July 9, 2025

**Re: Tierra Linda at 9801 Ceja Vista Rd. SW
Erosion and Sediment Control Plan (SWQ-2025-00036)
Engineer's Stamp Date 7/8/25 – P09E004**

Based on the information in your submittal received on 7/8/25, the ESC Plan and EPA Notice of Intent (NOI) can't be approved until the following comments are addressed.

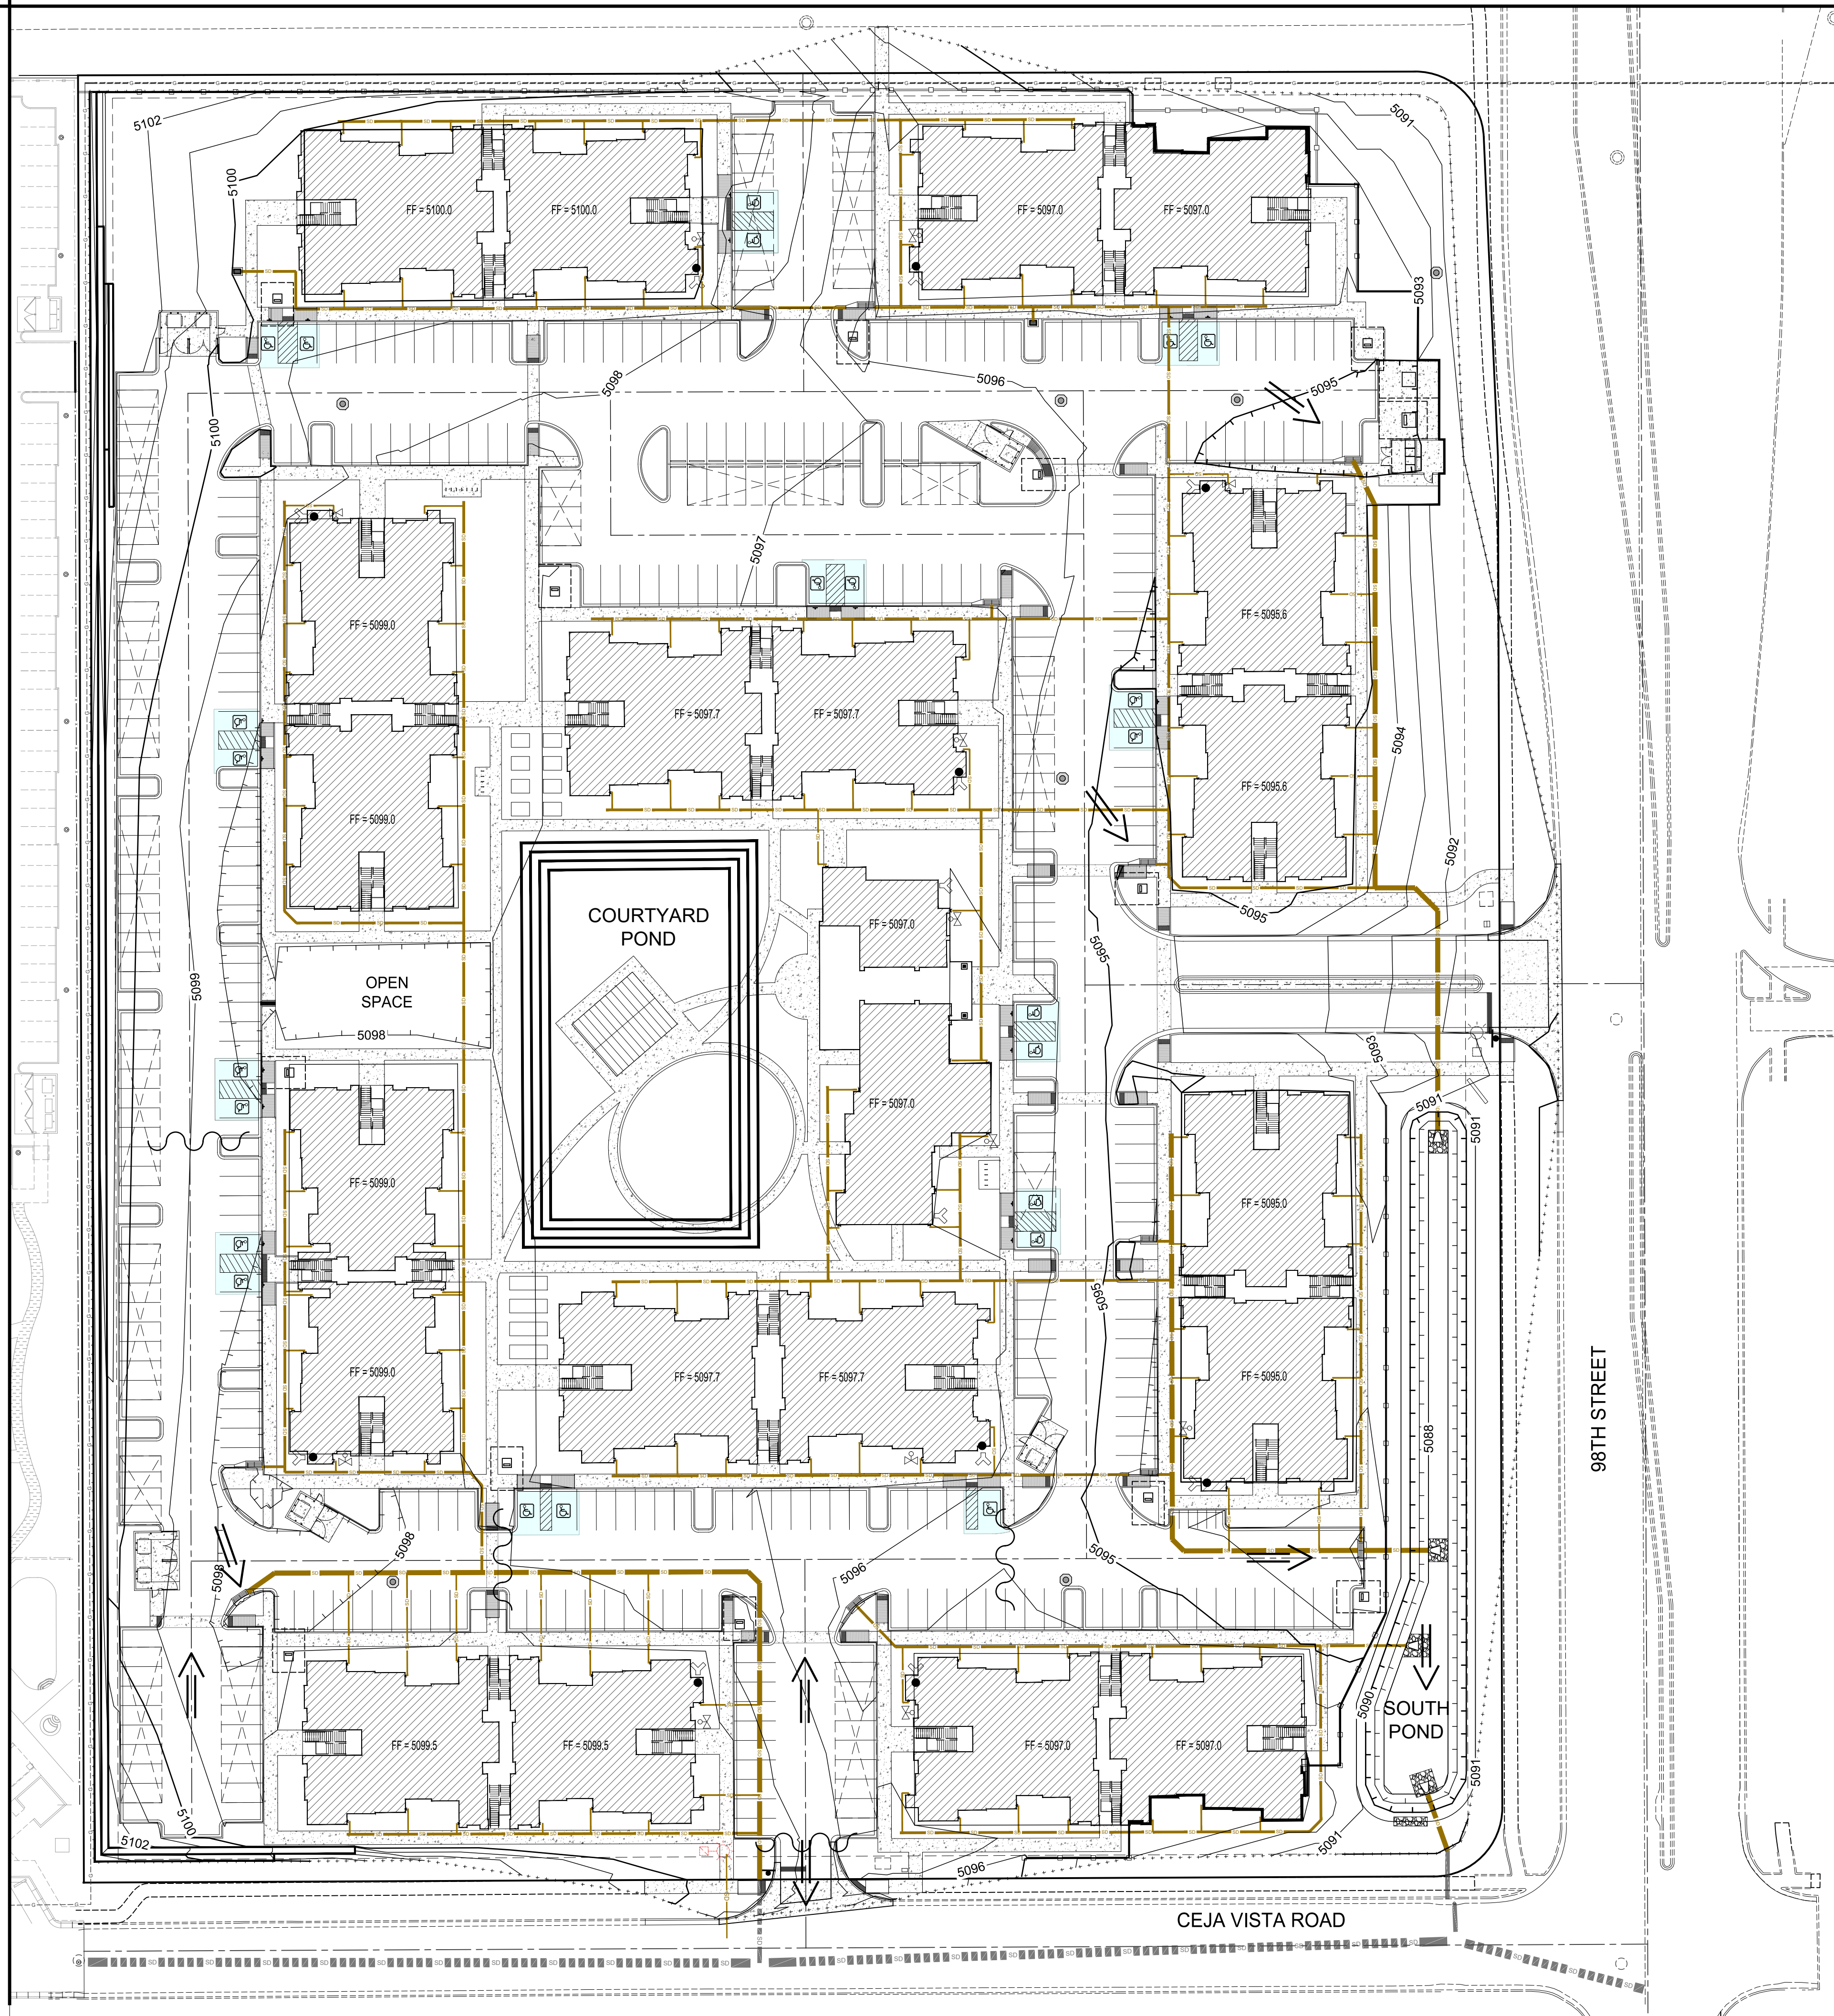
1. This new ESC Plan lacks the necessary information listed on the city's ESC Plan Checklist (see attached). This sheet may have been intended to address note #5 from the previous ESC Plan comment letter dated July 1, 2025, which stated, "Design calculations and construction specifications must be prepared in accordance with good engineering practices and certified by a registered professional engineer in accordance with CGP 9.6.1.c. and 2.2.12. for all temporary sediment traps on the ESC Plan," but the remaining ESC Plan sheets are missing. Each pond should be sized for the drainage area, yet the drainage areas are not indicated; the northeast drainage area does not appear to drain to a pond, and the south pond is undersized.

2. The NOI still shows the wrong area of disturbance.
3. The site-specific interim and permanent stabilization per CGP 9.6.1.c.i. is still missing.
4. The existing contours are still missing.

5. The additional BMPs are still missing
6. The off-site construction support activity note is still missing.
7. The schedule submitted does not show the timing of the temporary controls. A construction sequence must be included on the ESC Plan, identifying when each stormwater control will be built. and
